Our Ref: R/2017/14/O
File No: 2021/020318
Your Ref: SSD 8517 – MOD 7

Emily Dickson
Senior Planning Officer – Key Sites Assessments
Department of Planning, Industry and Environment

Request for advice – Locomotive Workshop MOD 7 – expand retail uses into Innovation Plaza (SSD 8517)

1 L0 PLAN EXTRACT - INNOVATION PLAZA NORTH
1 : 150

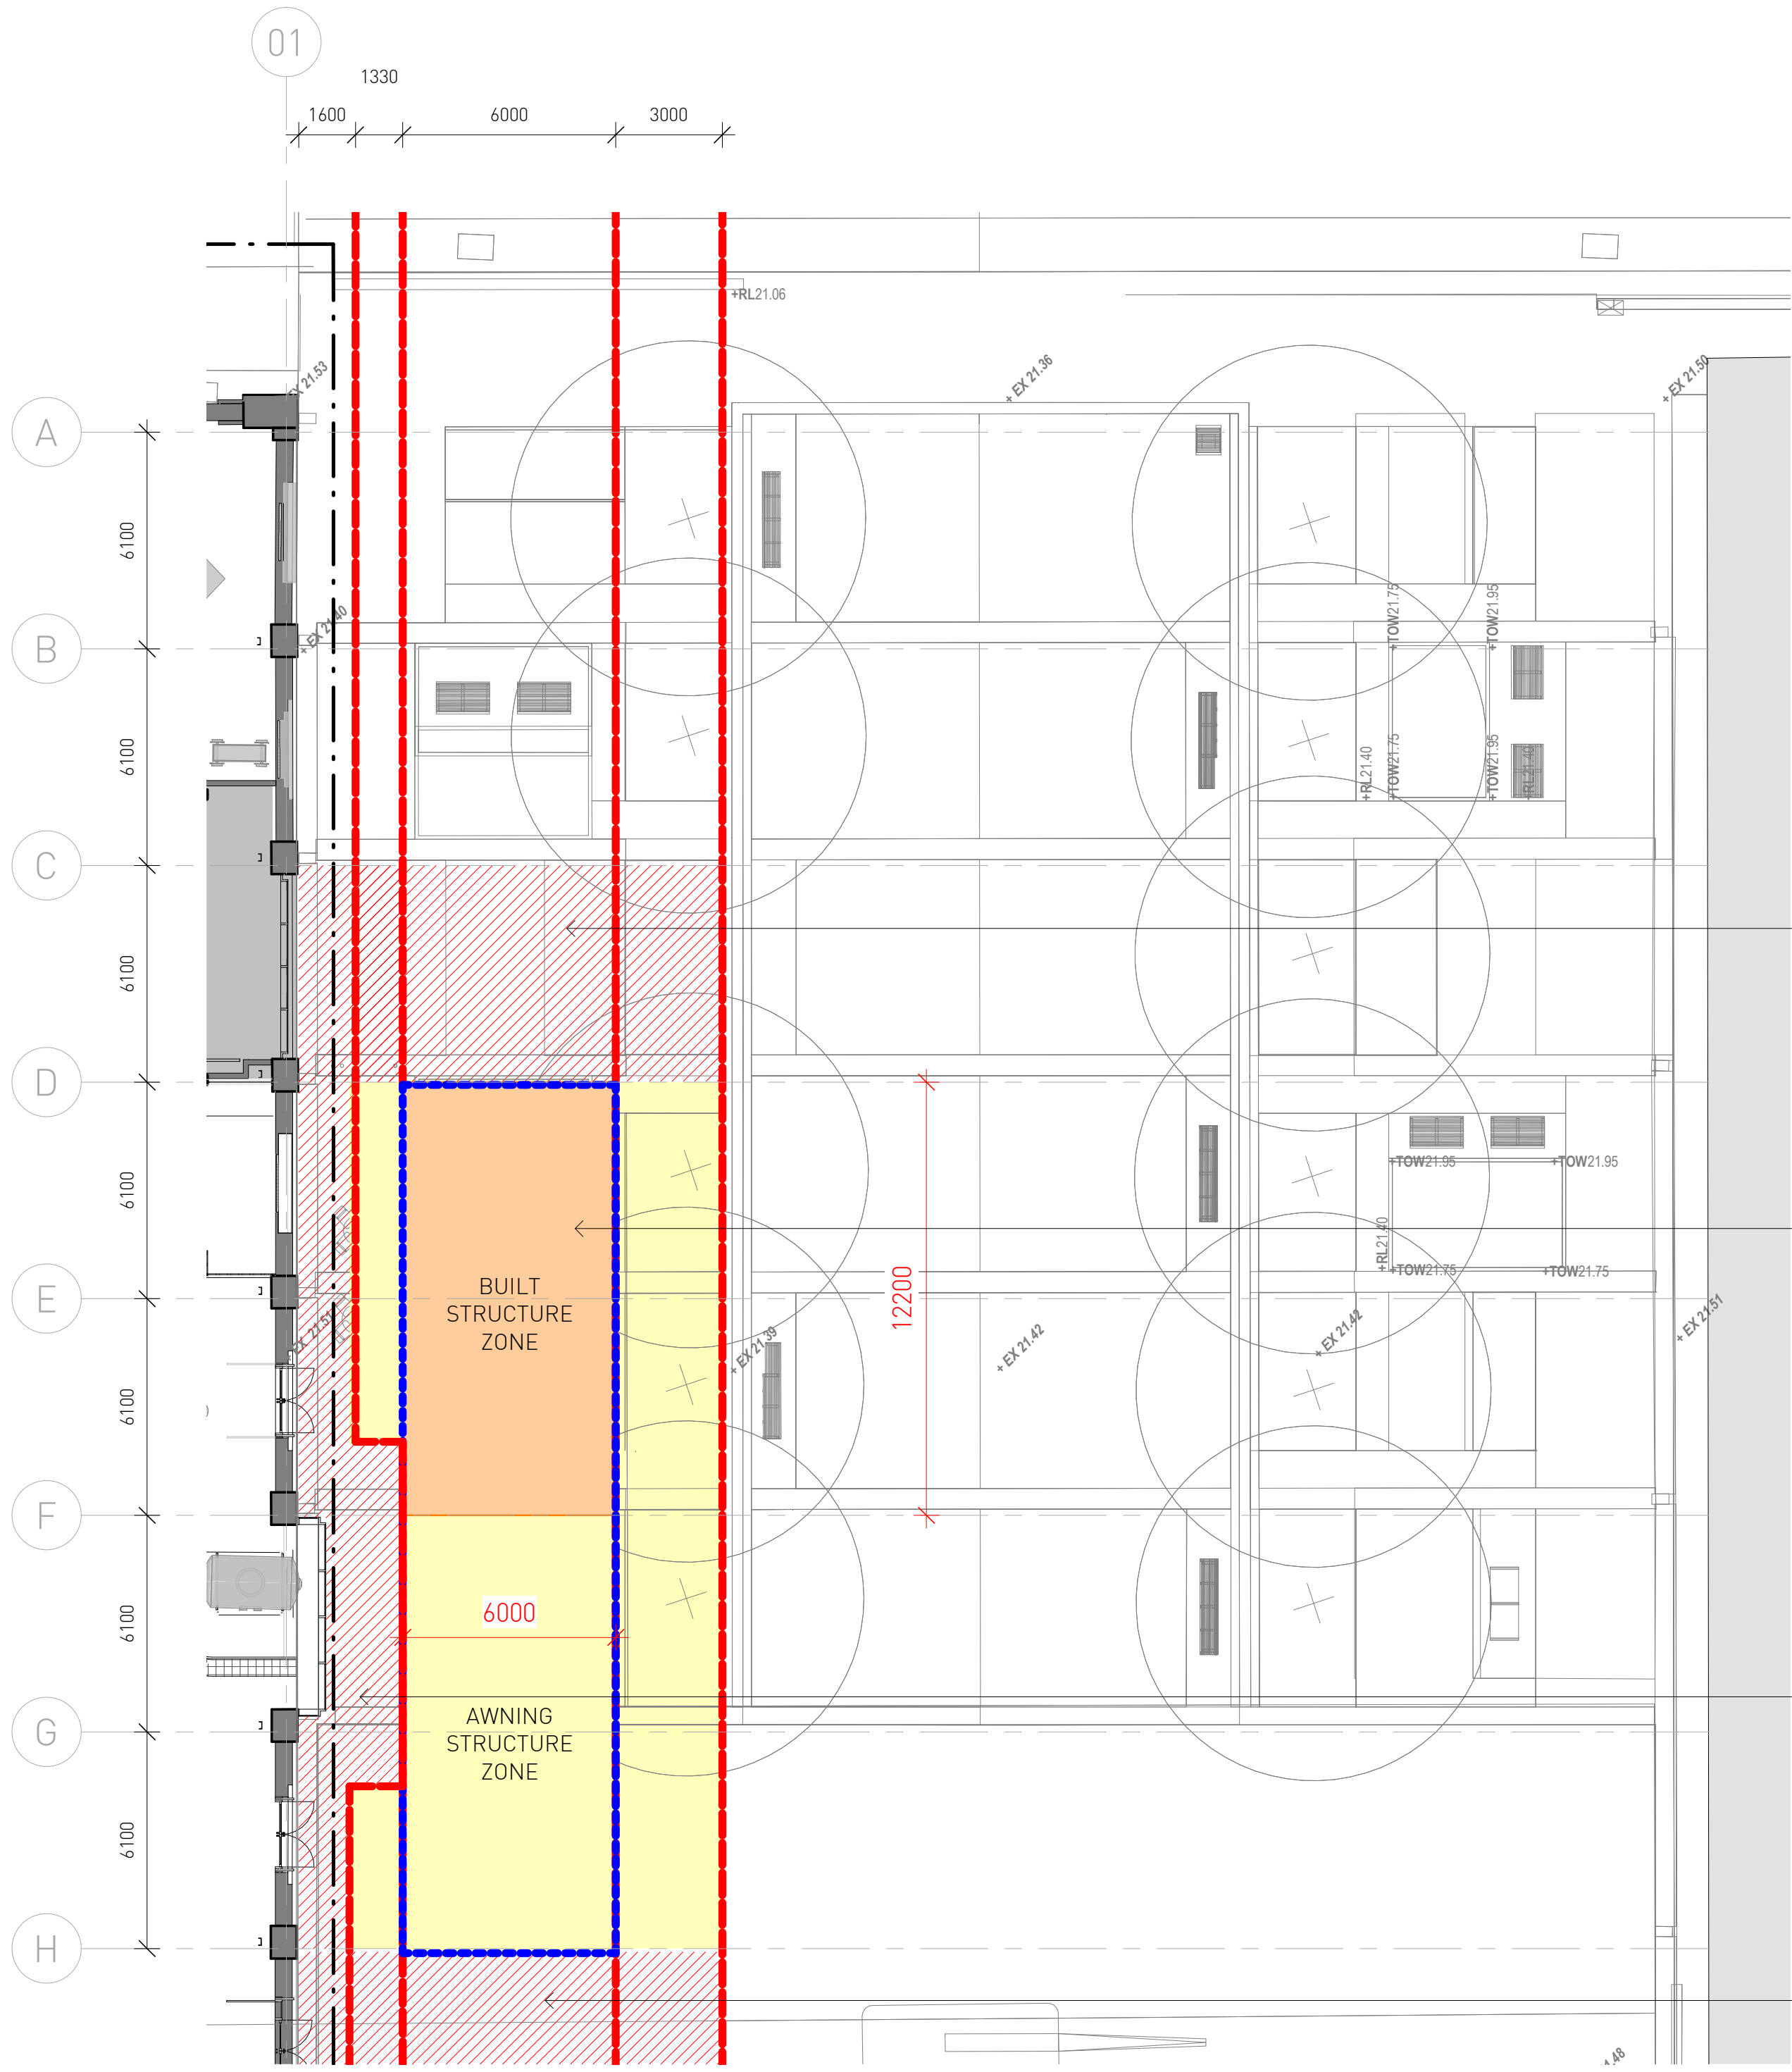
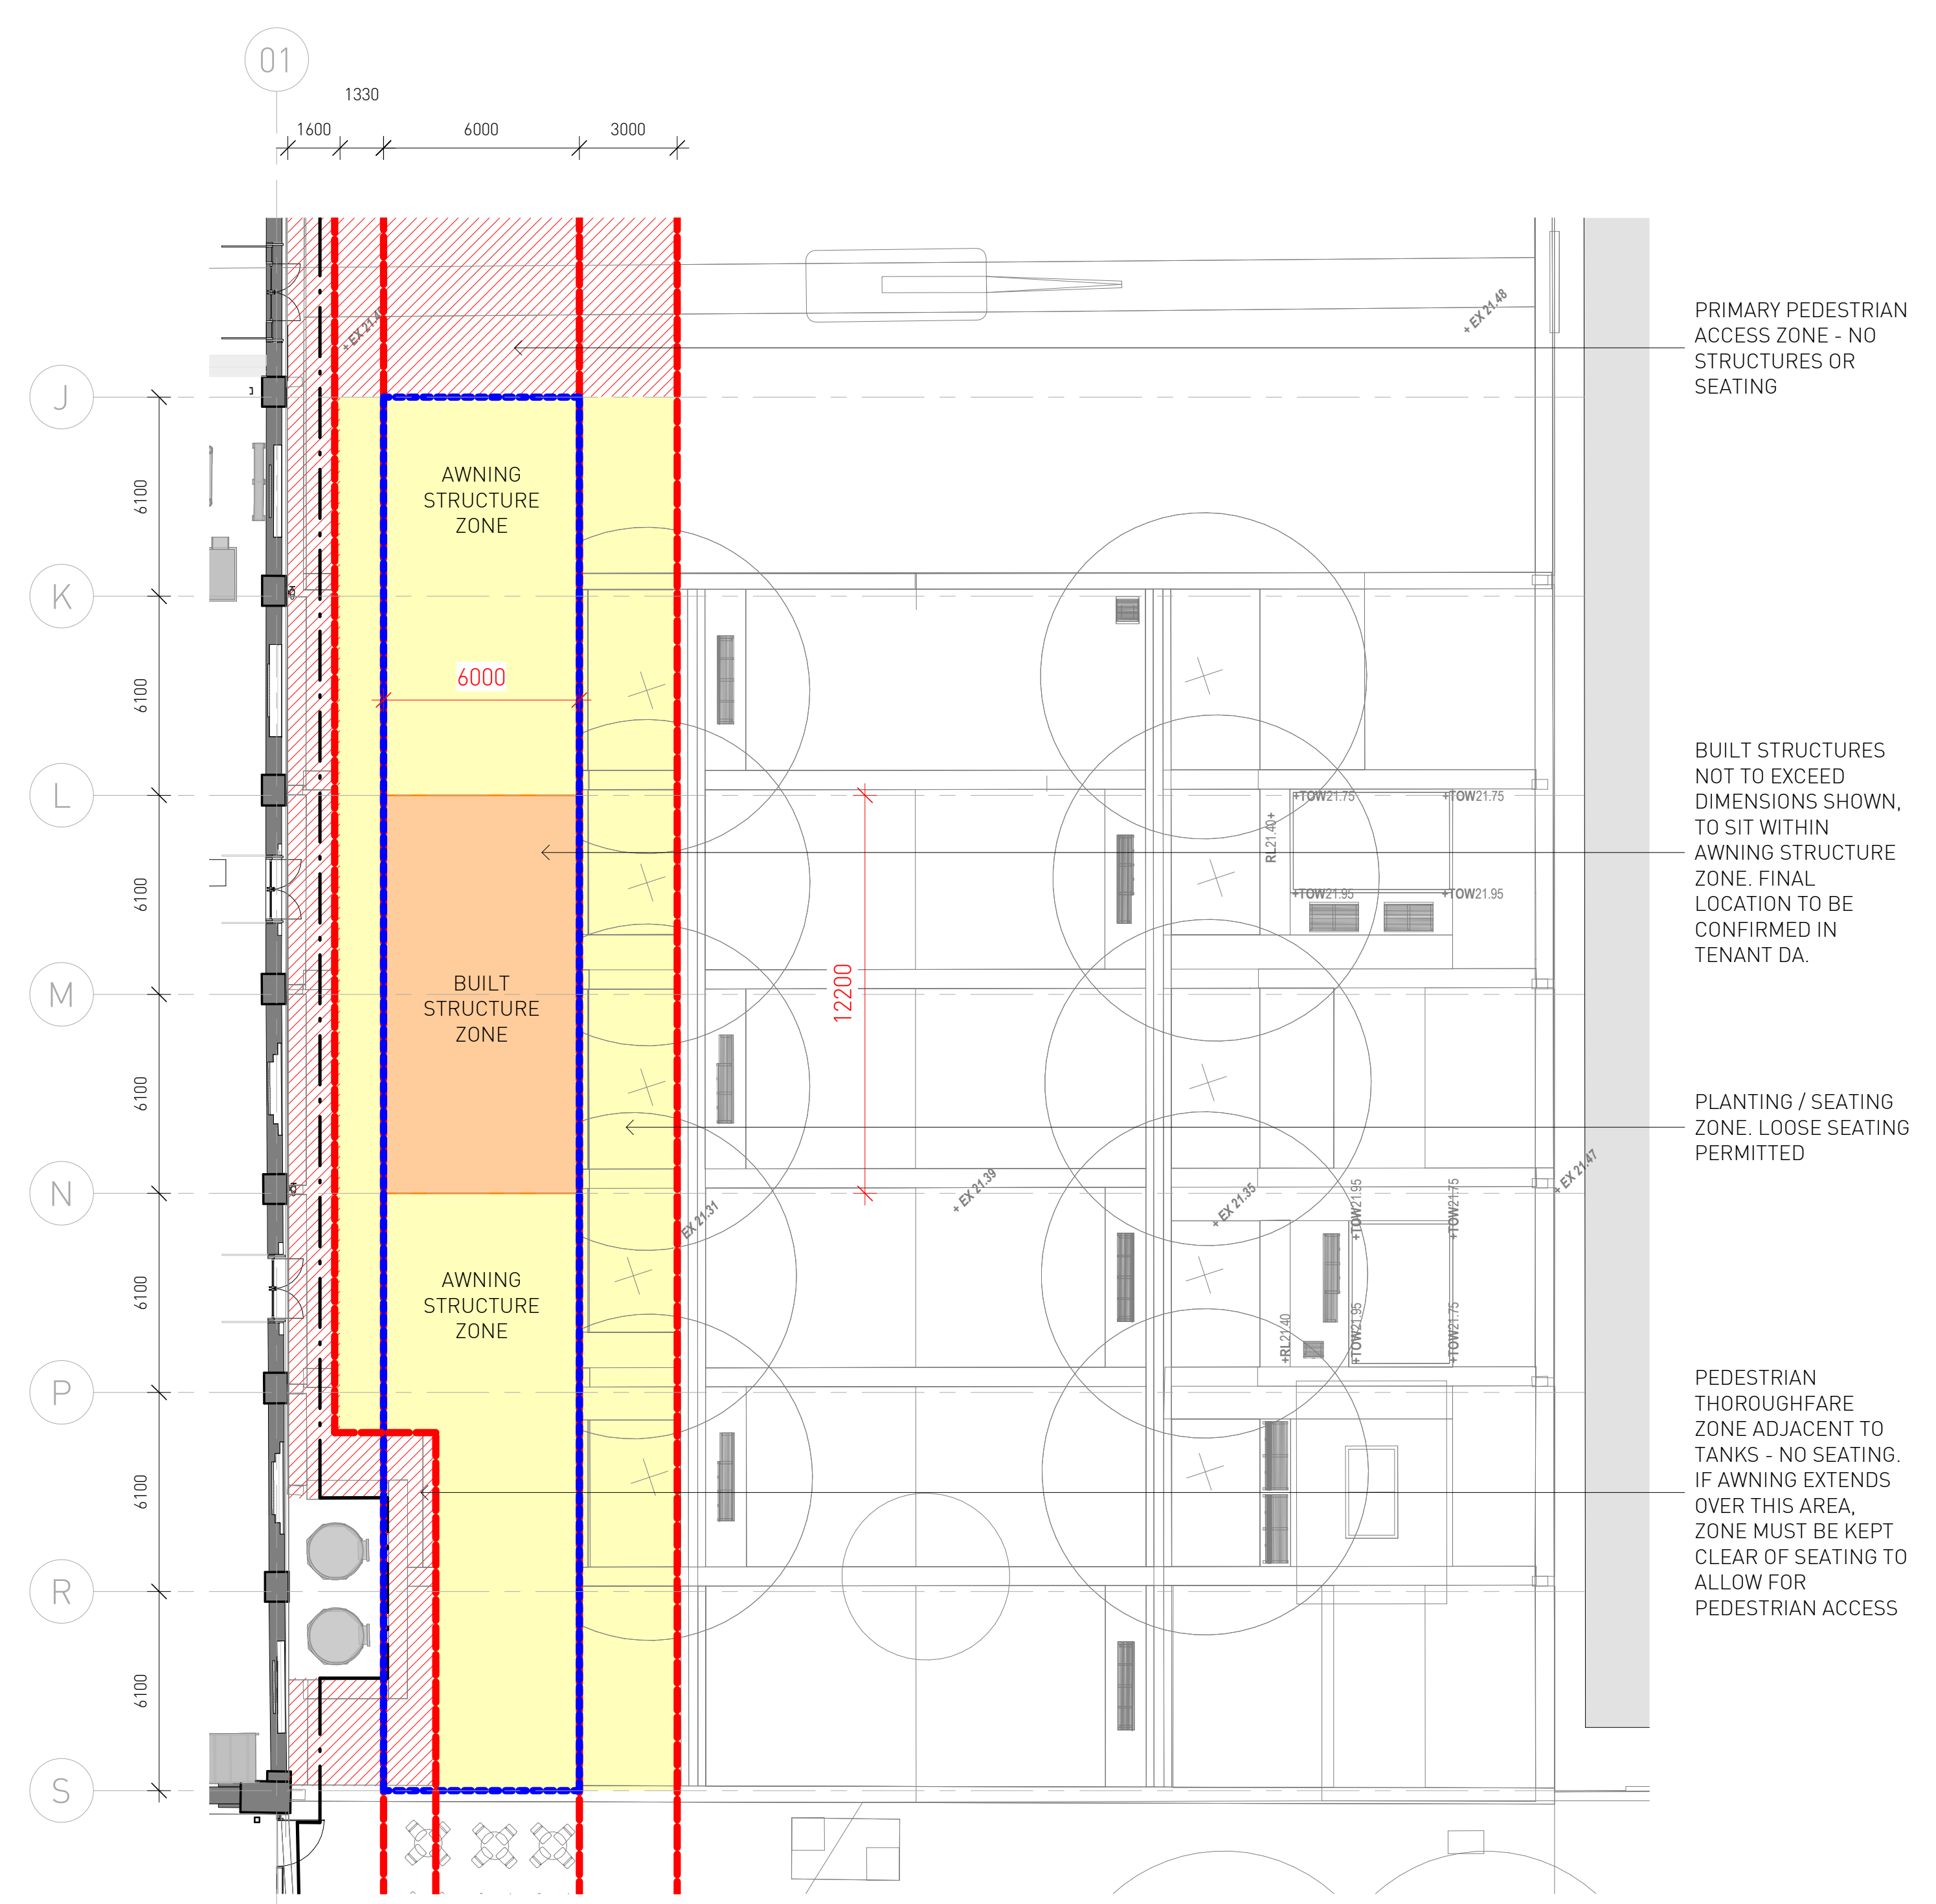
- To ensure that the vitality and safety of the community and public domain is achieved, the City recommends that the provision of tenant outdoor seating zones located 1.6m from the Locomotive Workshop building line and outside of the proposed envelopes be deleted. This would allow for a generous width of travel to avoid crowding and increase the safety of people, particularly with impaired vision, to easily traverse and navigate this space.
- Having regard to the above, a path of travel free of structures would simultaneously improve the visual and spatial relationship of any future structures with Locomotive Workshops and allow the building to be discerned.

- The provision of outdoor seating and any built form and awning structure envelopes must not compromise and impede on the existing trees located within Innovation Plaza. The trees are vital public domain elements that positively contributes to the visual and aesthetic value as well as to the amenity of the area and must be protected.
